**Notice of Exhibition – Sydney Metro City and Southwest (Chatswood to Sydenham) Modification 2 – “Central Walk” (SSI 7400 MOD 2)**

I refer to your letter dated 18 June 2017 which invites the City of Sydney (“the City”) to comment on the request for modification of the Sydney Metro City and Southwest (Chatswood to Sydenham) project approval.

Figure 1: Indicative design layout of Central Walk (TfNSW 2017)

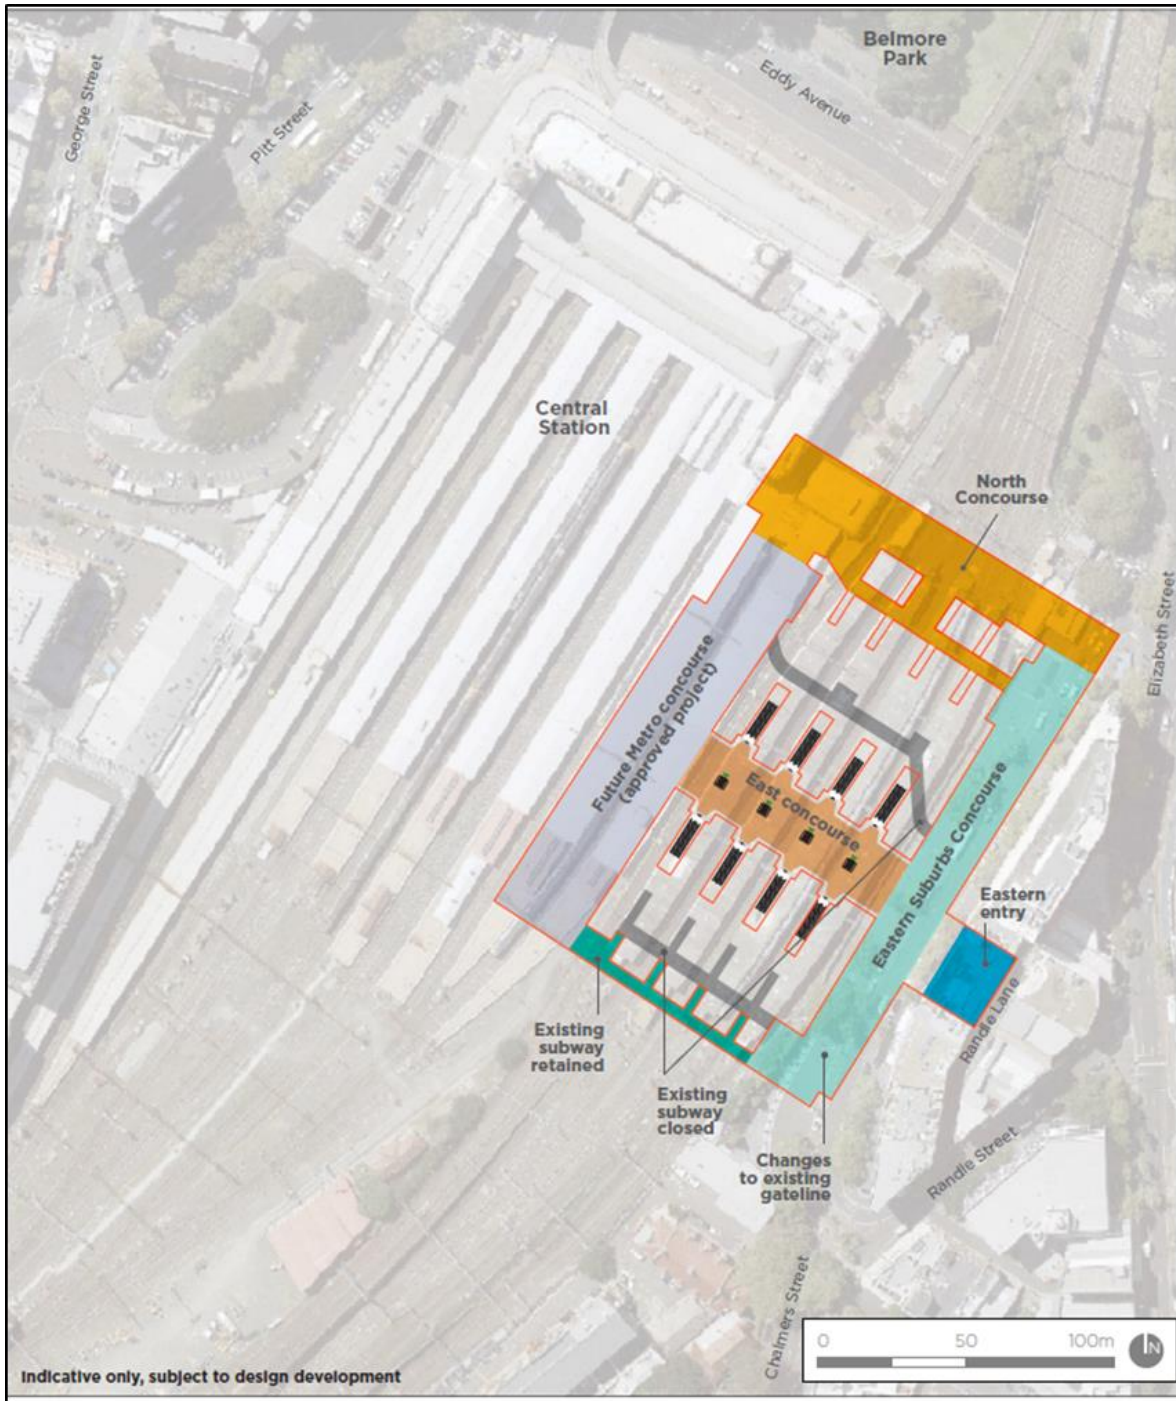
The City notes that the current design provides for access to the eastern section of central walk to from the eastern side of Chalmers Street only.

There should also be provision for access and vertical circulation on the western side of Chalmers Street by lift and escalators in order to serve the large number of customers moving between the inbound light rail platform and Central Station and reduce the conflicts between people crossing Chalmers Street and light rail

Central Walk will be a major civic landmark as a new major address/access point to the Central Station transport hub. It is in a location with a clear and predominant masonry street wall and should be designed as a high quality infill to this context. The functional need for large access portals and windows for daylighting the subgrade escalators and stairs will need to be balanced with passive solar control measures to deal with heat gain and glare arising from the North West aspect of the primary façade.

The rear elevation of the building to Randle Lane should also be of high quality to complement proposed developments currently under assessment on the facing east side of Randle Lane, and should be designed to improve the activation and supervision of Randle Lane.

Figure 3: NML exceedances for night time enabling works for combined approved project and Central Walk modification. Red indicates an NML exceedance of 20dB or more, orange 10-20dB, yellow exceedances between 1-10dB, and green indicates compliance with the NML (TfNSW 2017).

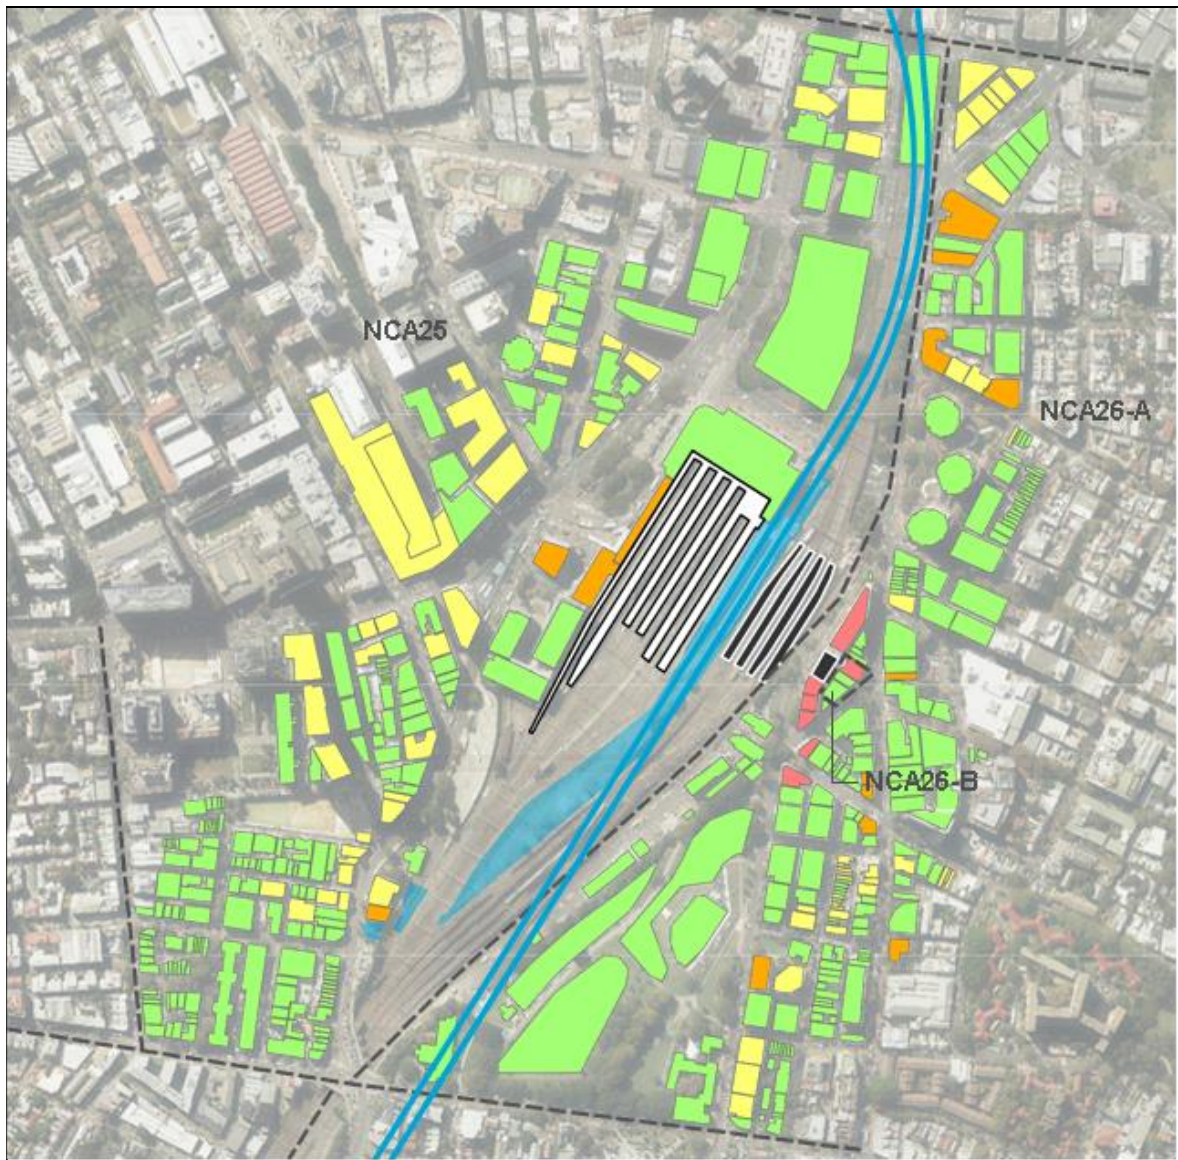
- The report emphasises that at most locations that surround central station there will be no more than a 1% increase in noise associated with the modification works. However the City points out that the works associated with the modification are localised and the impacts at that locality can be expected to be produced.
- The construction activities for the proposed modification would result in some additional exceedances for some receivers. The receivers which would experience the largest potential change in impacts are those located in the immediate vicinity of the proposed eastern entry.

- The receivers noted above are likely to be impacted by noise levels in the order of up to and over 20 dB above the set noise criteria. This will result in day, evening, and night noise levels of 86 to 88, 78 to 81 and 70 to 77 respectively at residential receivers. It is understood that the Sydney Dental Hospital has an internal noise criteria of 45dB set, and is indicated as having noise criteria exceedance in the order of or over 20dB, effectively meaning internal noise levels of 65+dB. Similarly, commercial noise receivers subject to 20 dB criteria exceedances will be subject to noise levels of 70dB where they have an internal noise level of 50.

- The City is of the view that this degree of noise impact will potentially have considerable effect on the occupants of the building, particularly the residents and the dental hospital, and that the targeted consultation with these receivers is appropriate in addition to planning to implement alternative treatments, noise mitigations and processes instead of waiting for associated complaints to occur in the future.
